Our Ref: 2025/415235

Council Comments - SSD-69850712 - 1-3 Skyline Place, Frenchs Forest

APPENDIX 1 - DETAILED COMMENTS FOR SSD-69850712 NORTHERN BEACHES COUNCIL

Figure 1 Proposed massing (Source: Smith & Tzannes)

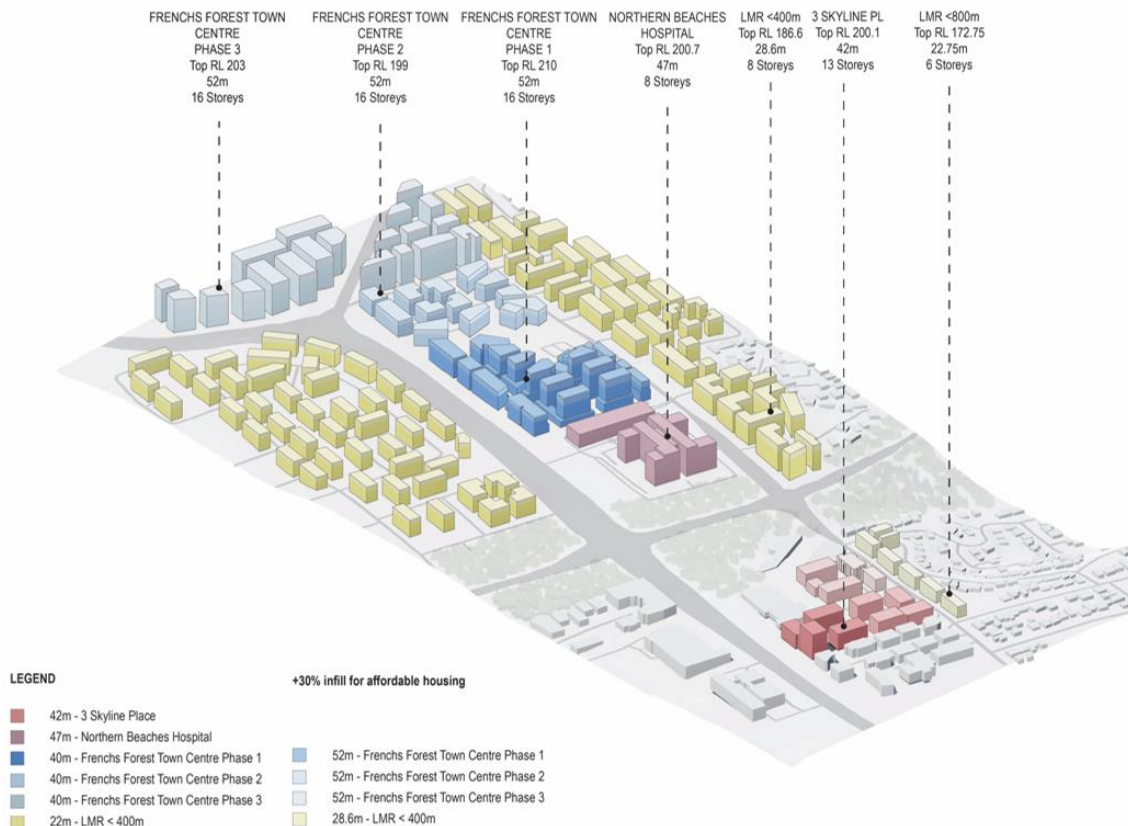
- A transition to eight storeys is above the six and seven storey buildings proposed, but is concentrated in the middle of the site.
- Building C at 14 storeys at the southern corner of the site along Warringah Road is not consistent with height and density in this location and represents an overdevelopment of this portion of the site.

- The height of Building C is over 45 metres (as shown on Stage 1 DA Drawing 202). The Northern Beaches Hospital has a height of 40 metres. A height of 14 storeys is unjustified and unsupported.

- The maximum height for Building C should be six storeys, consistent with the western part of Building C and consistent with the transition of height at the perimeters of the subject site.
